From: Nicola Swann [REDACTED]
Sent: 14 July 2021 11:50
To: Planning.Responses <Planning.Responses@arun.gov.uk>
Subject: Pagham responses

Pagham Parish Council considered the following applications at a meeting of its Planning Committee Advisory Group meeting held on 13th July 2021. In accordance with a scheme of delegation dated 4th May 2021, the Clerk submits the following comments on behalf of the Council:

P/95/21/PL – Bowley Farm Bowley Lane South Mundham Chichester PO21 1NB. Retention of 4 mobile homes for countryside workers together with drainage and service connection provision in connection with permission P/72/09 as varied by P/22/17/PL (resubmission following P/86/20/PL). This site is in CIL Zone 5 (zero rated) as other development.

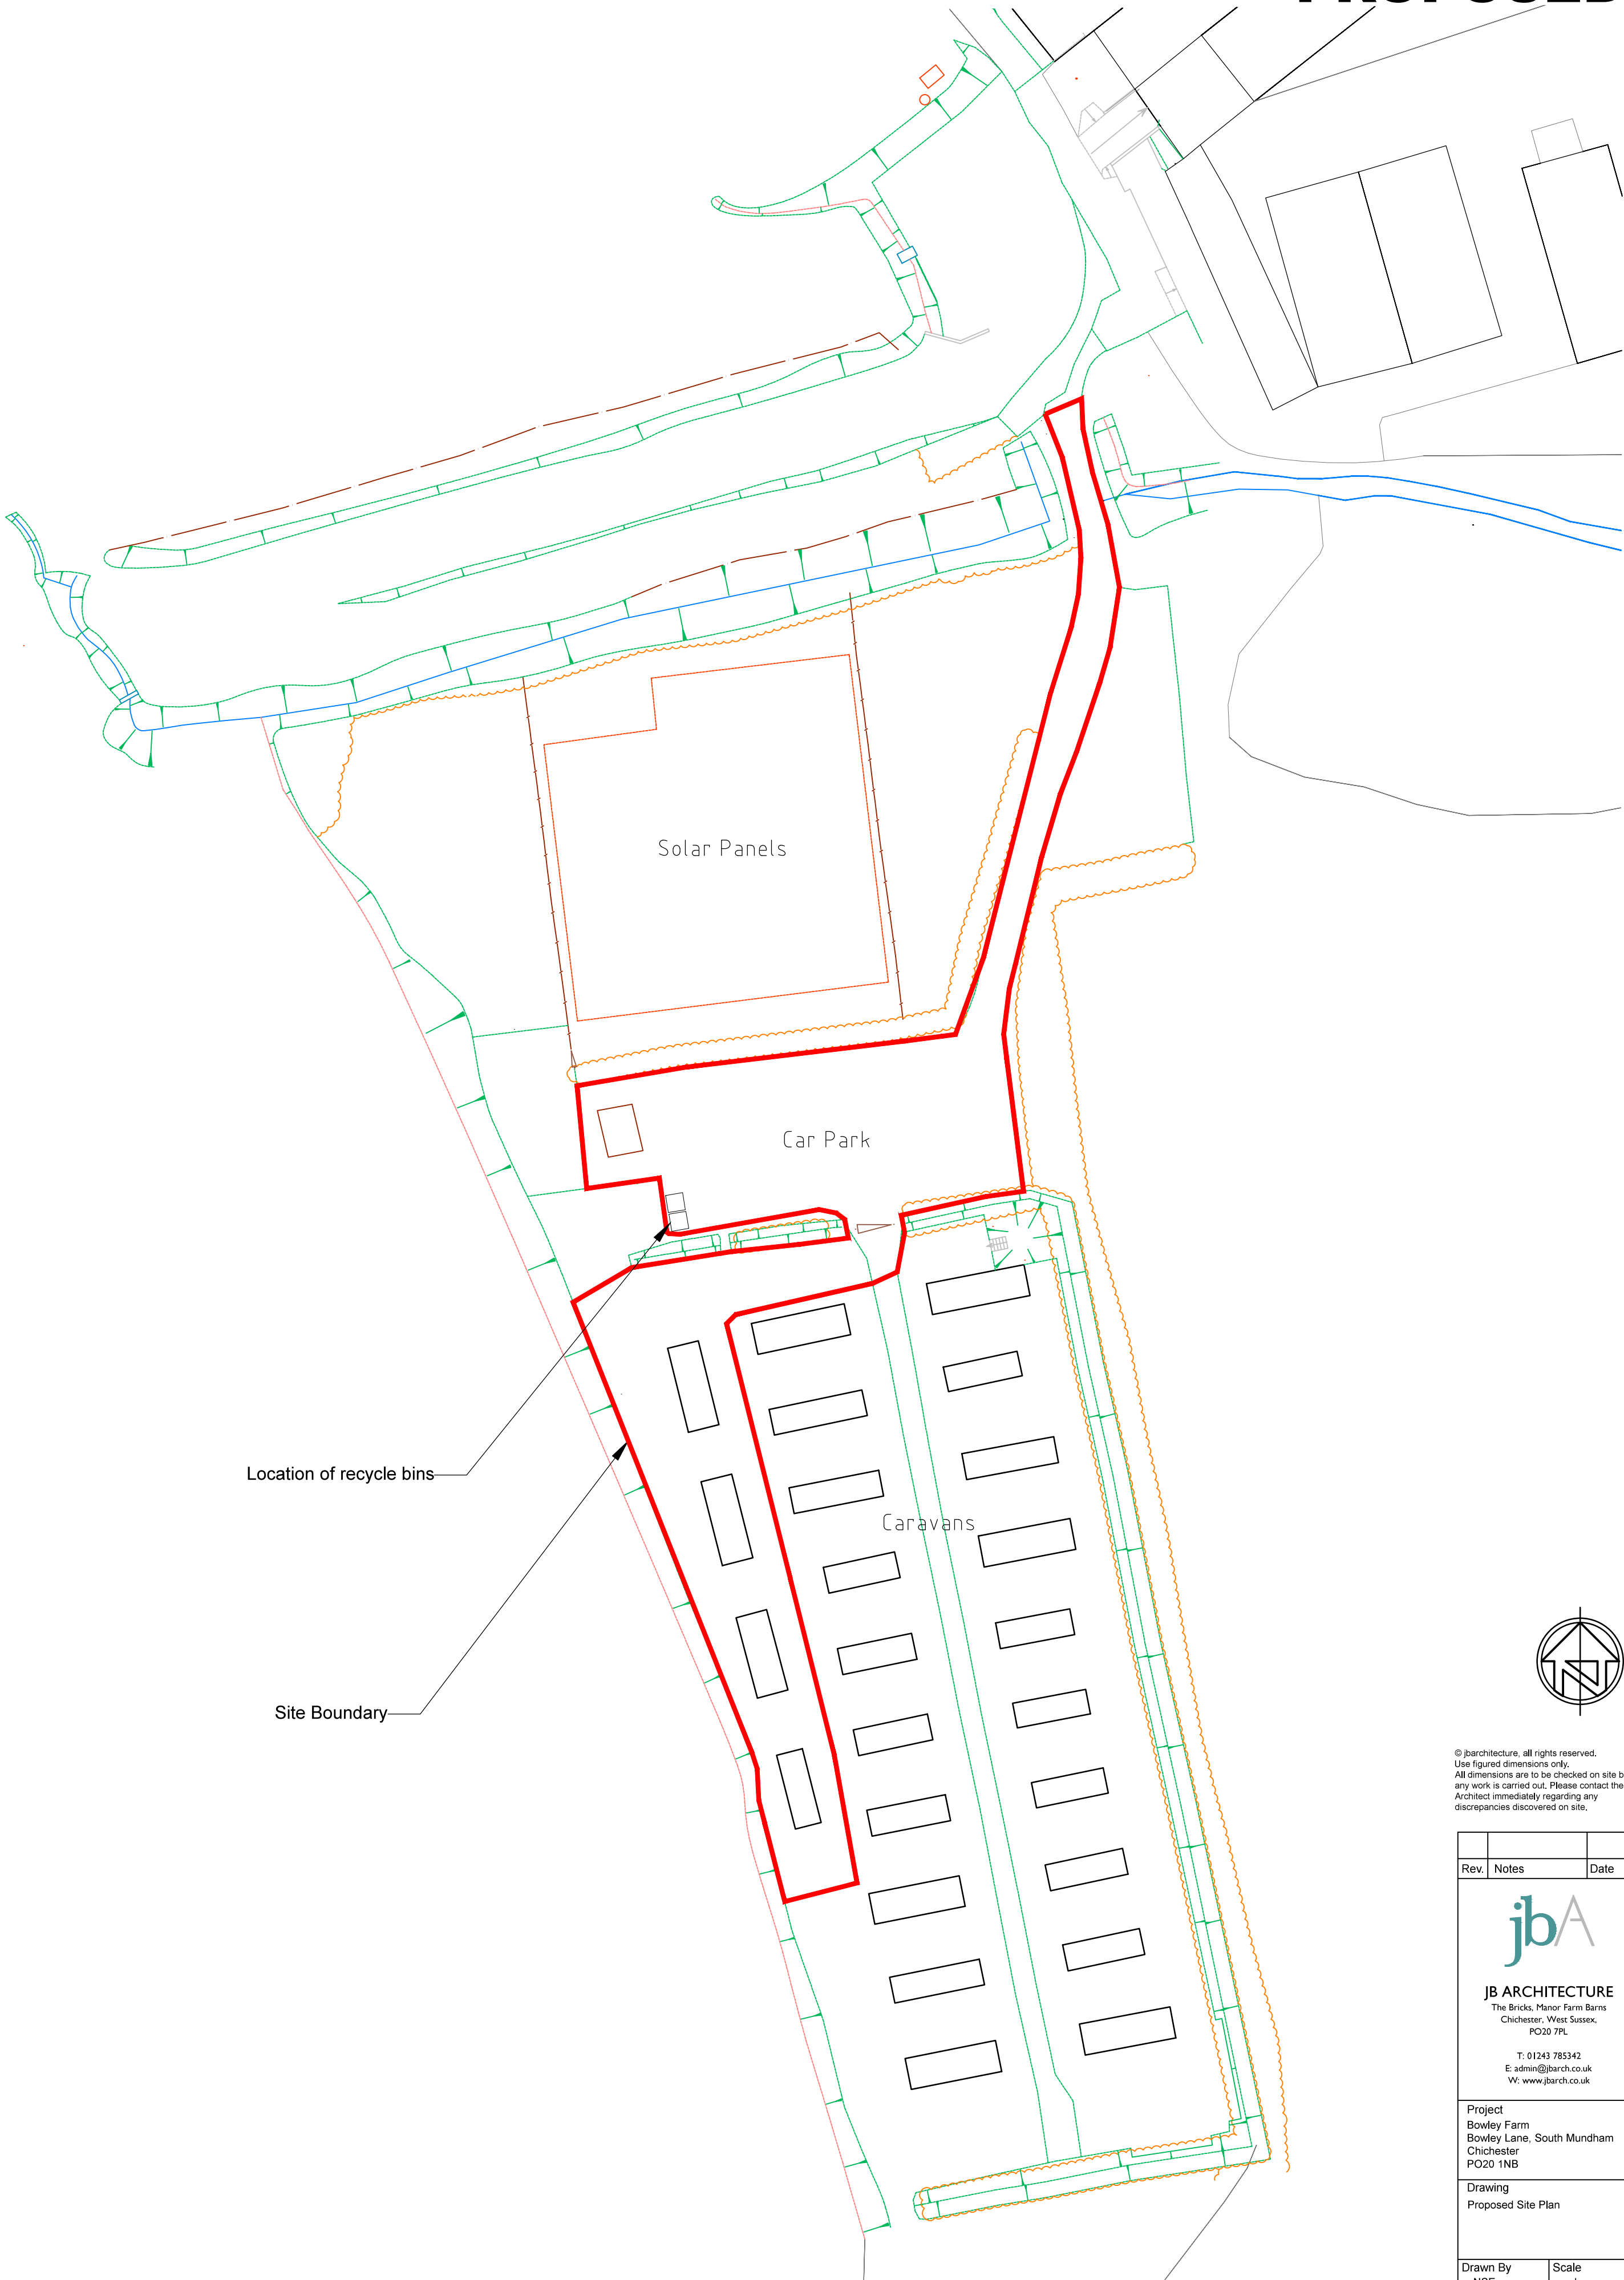
OBJECT. The Council was concerned to note the comments of the Officer representing FRS Water and Access, regarding the proximity of the caravans to the nearest fire hydrant. The Council would also wish to be assured that the access meets the standards as outlined in the Officer's letter of 9th July 2021.

Furthermore, there is no consultation response from ADC's own drainage team. Given the proximity of the rife, Members wanted to be assured that the drainage team had been consulted before this application is determined.
